From: [PMO](#)
To: [Wylfa Newydd](#)
Subject: RE: IACC Deadline 2 Submission : Local Impact Report - Introduction (email 3)
Date: 04 December 2018 20:37:35
Attachments: [image001.png](#)
[image002.png](#)
[image003.png](#)
[Annex 1D-1O \(Batch 2 of 2\).zip](#)

Mr Kieran Somers
Horizon Nuclear Power
Sunrise House
1420 Charlton Court
Gloucester Business Park
Gloucester
GL3 4AE

Review of Horizon's DCO Submission (Dalar Hir)

FIGURE F1-4

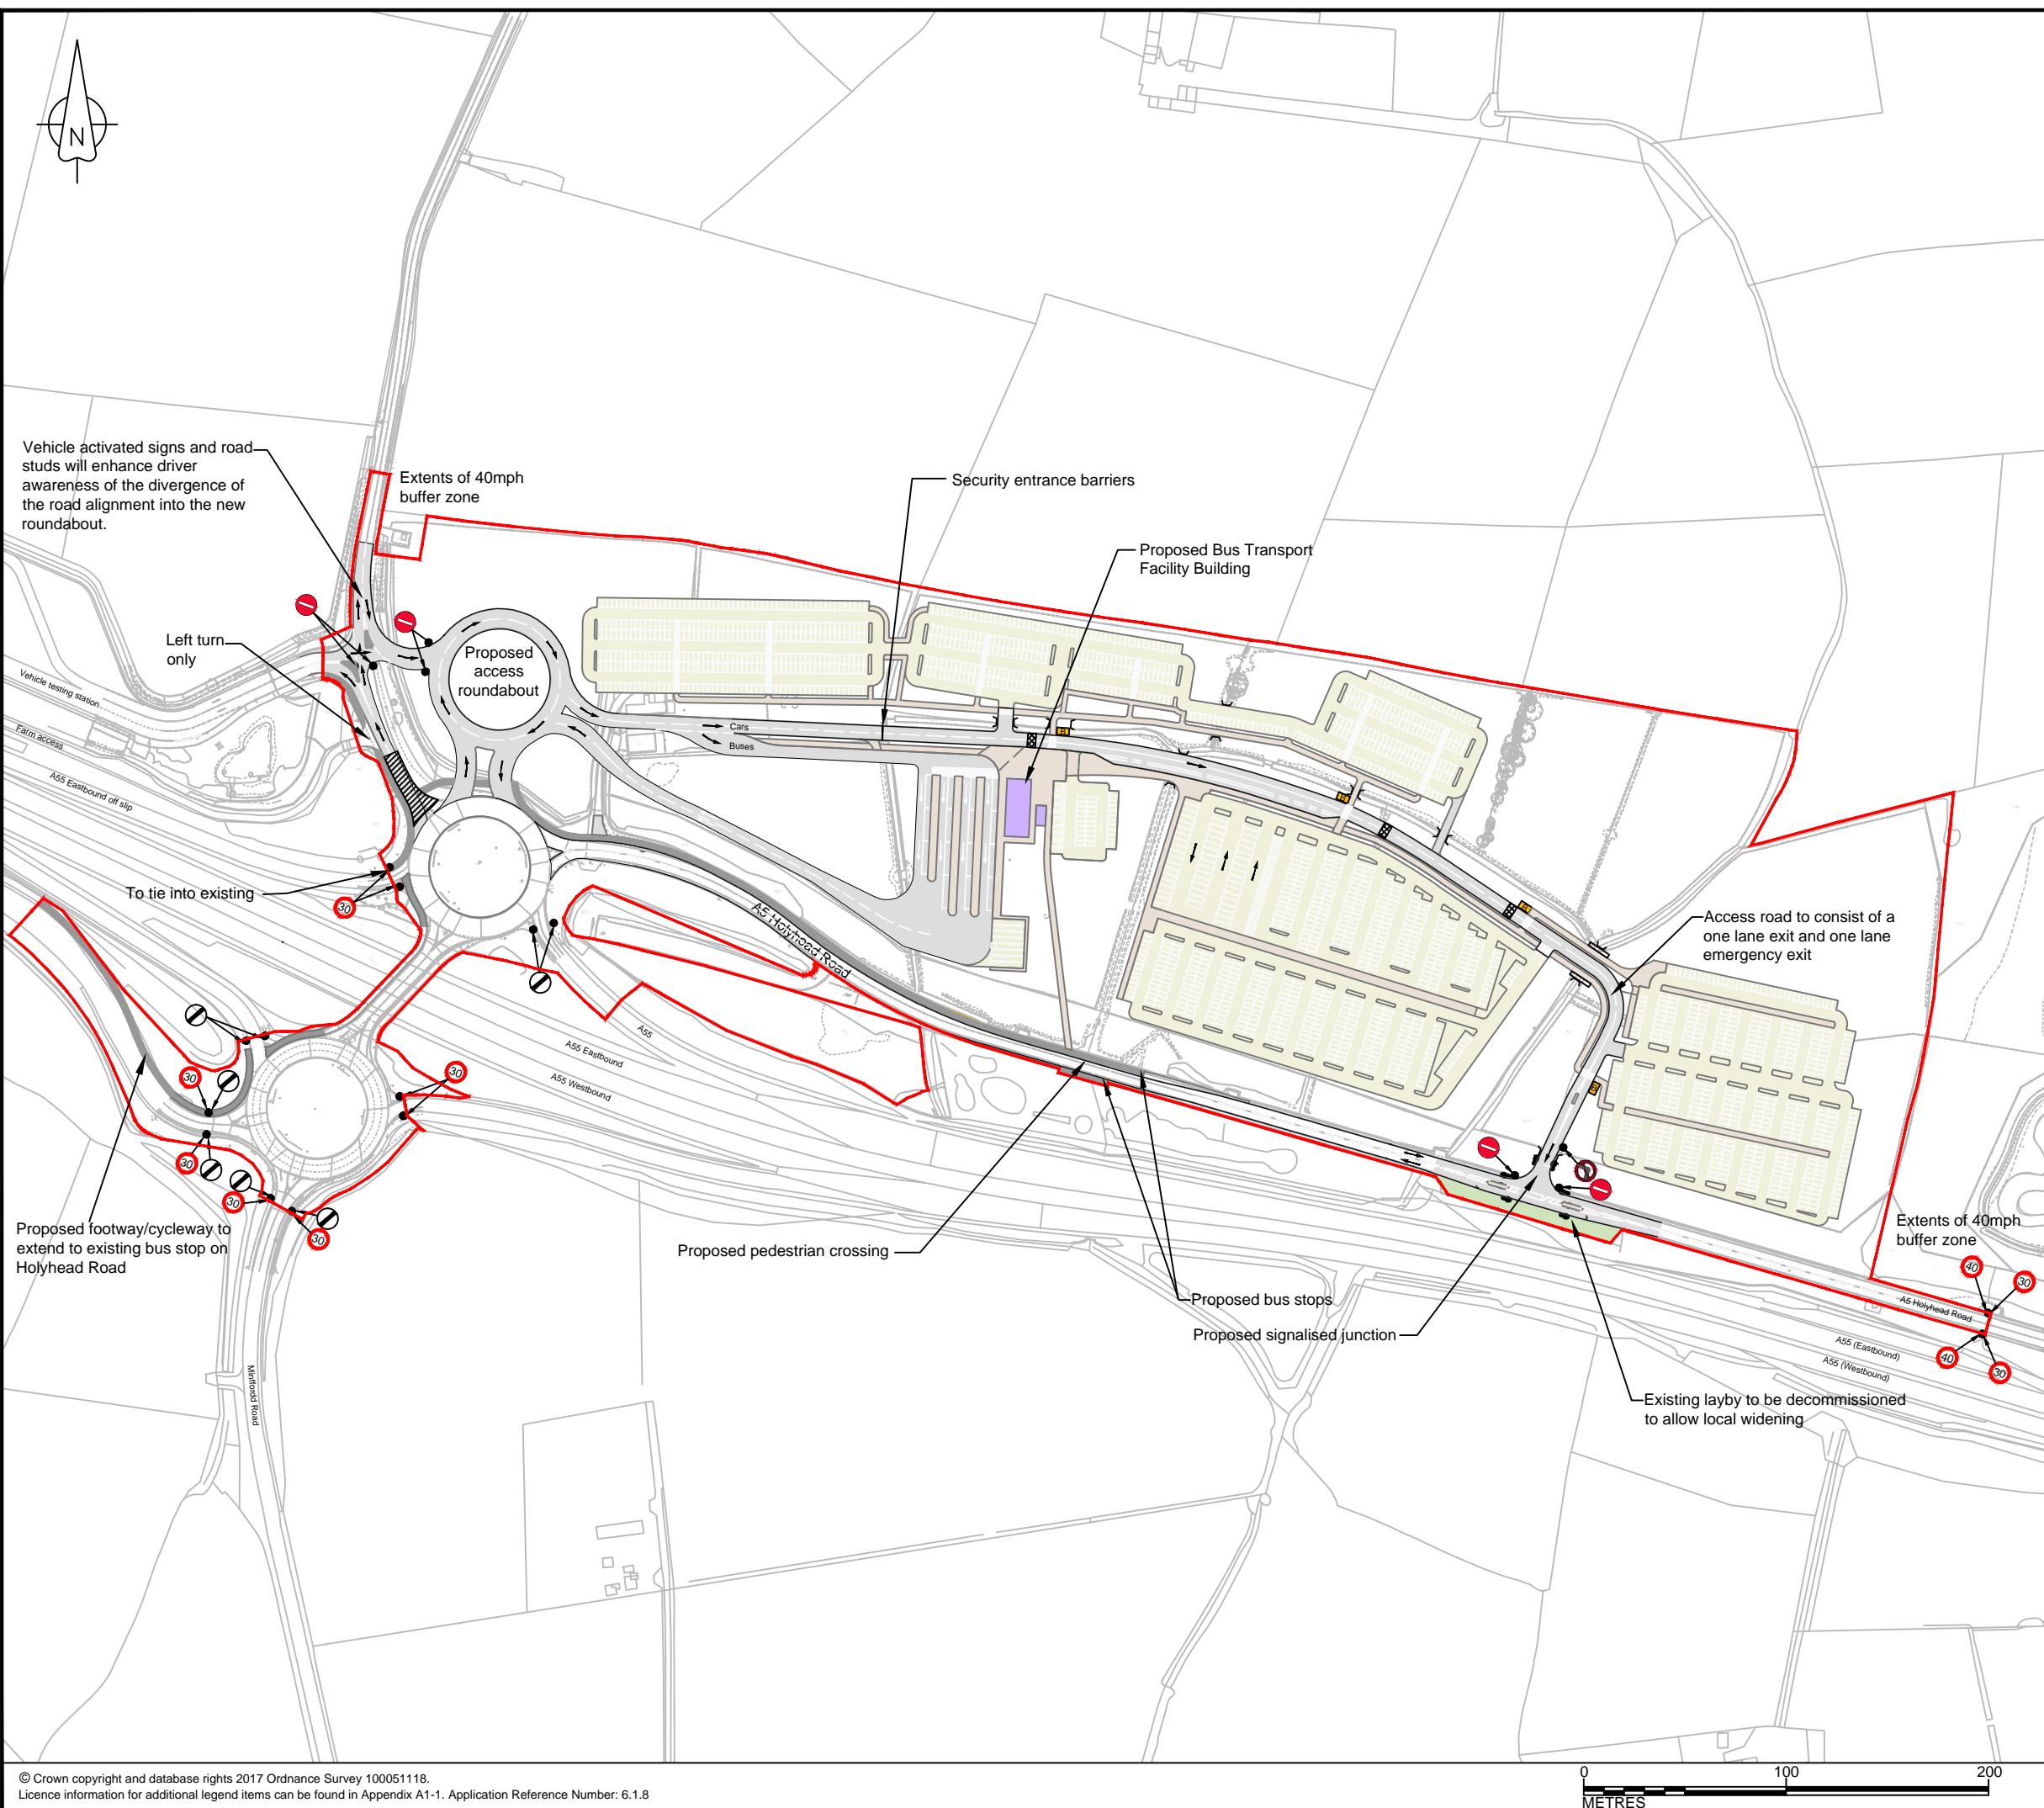
Figure F1-4 of the Figures Booklet shows proposed bus shelters within the park and ride facility. It is unclear whether the local bus service will have access onto the site to drop off people at these bus stops to encourage more people to use local bus service to access the park and ride facility. To encourage additional public transport journeys to the site consideration could be given to facilitating the provision of additional local bus services during peak time at the start and end of the shift as an option to the use of private cars. This would further reduce the number of car journeys in line with National Planning Policy and align with criterion 12 of Policy PS 12. This is in line with clause (f) of criterion (ix) in Guiding Principle GP 15 of the Wylfa Newydd SPG (2018) which states 'Improvement to public transport services, particularly bus and rail provision.' Policy ISA 1 of the JLDP in reference to contributions for infrastructure list transport infrastructure including public transport.
